**Application by Norfolk Vanguard Limited**

**Norfolk Vanguard Offshore Wind Farm**

**The Examining Authority's further (second) written questions and requests for information**

**Issued on 27 February 2019**

Figure 1 Location of Old Railway Gatehouse

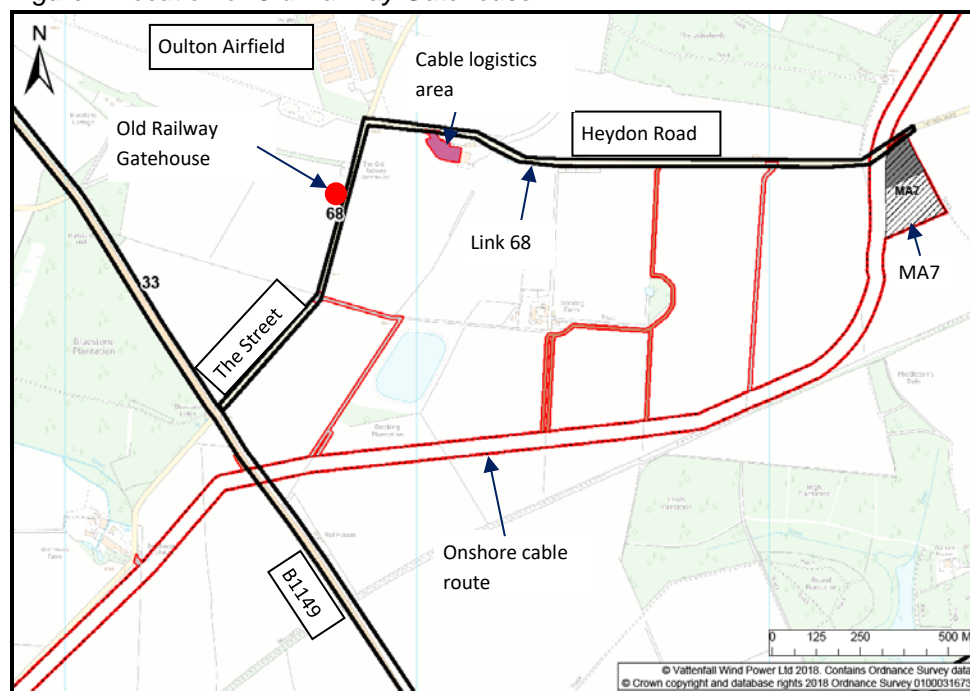
13.15	Applicant, Broadland Council	What implications does Appeal Ref: APP/K2610/A/14/2212257 have for the proposed development? Was the impact of noise and vibration on the Old Railway Gatehouse taken into consideration?
